Town & Country Planning Act 1990 (as amended)
Town & country Planning (Development Management Procedure) (England) Order 2015
Application for Planning Permission for Works or Extension to a Dwelling

Development Single storey front extensions & first floor front extension.

Location 37 Sea Avenue Rustington

SIDE ELEVATION (SOUTH)

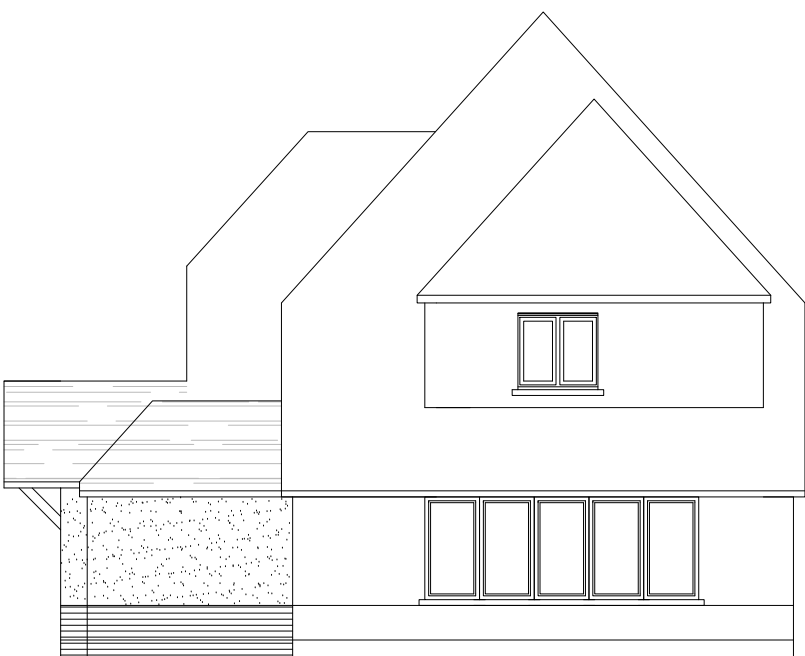
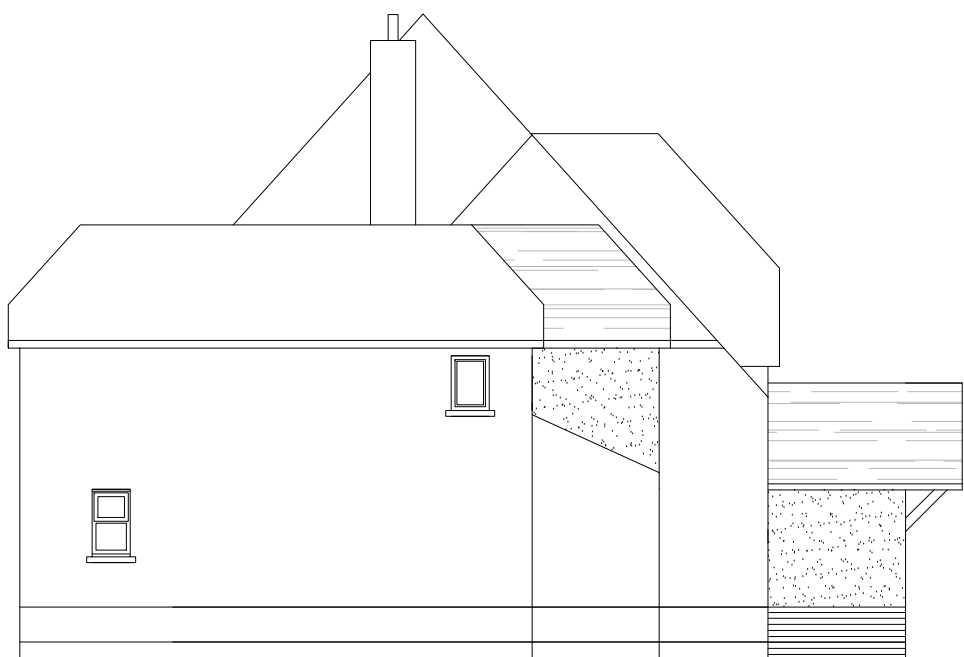
The existing ground floor plan and north elevation do not accord. Please amend accordingly.

The existing and proposed first floor plans and south elevations do not accord. Please amend accordingly.
